STATE OF NORTH CAROLINA
DEPARTMENT OF TRANSPORTATION

Addendum No. 1

RE: Contract # C204044

5 Sections Of US-15/501, 1 Section of US-64

Drawing file: 001 Plans / 001_007_Chatham_July_2017_Typ_3 sheet 7 rev 7-5-17.pdf

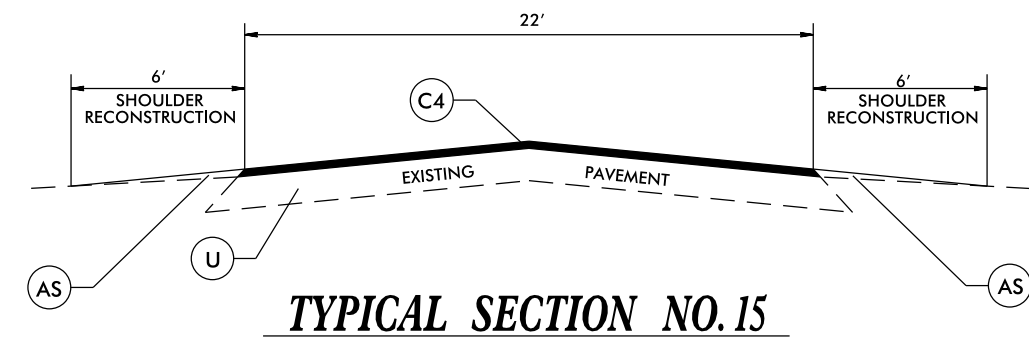
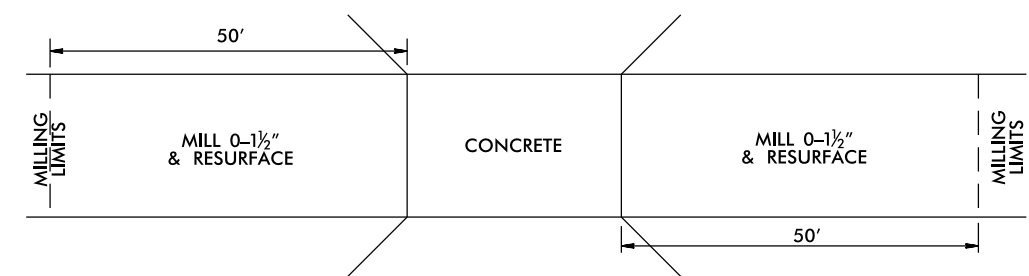
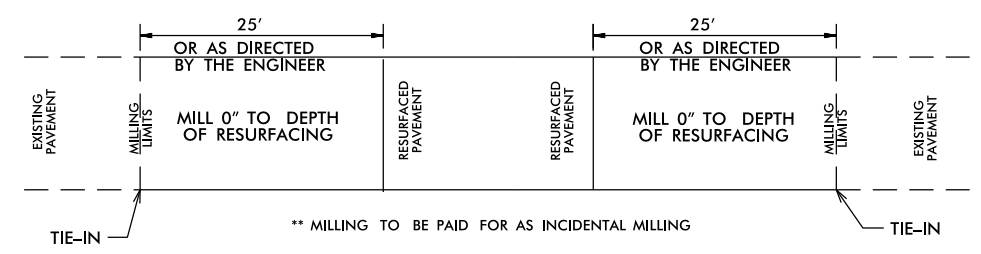
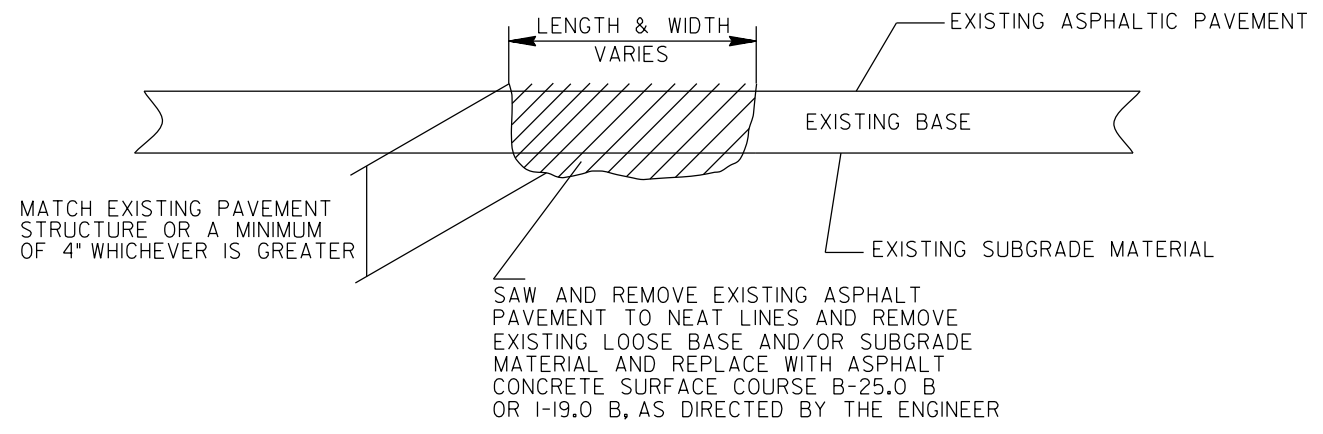
Sheet No.	Revisions
5, 6 and 7	Revised to remove C5 from the "Pavement Schedule". Also on Sheet No. 7 the patching detail was revised to reduce the depth of patching required
11	Revised to correct the quantity of "Incidental Milling"
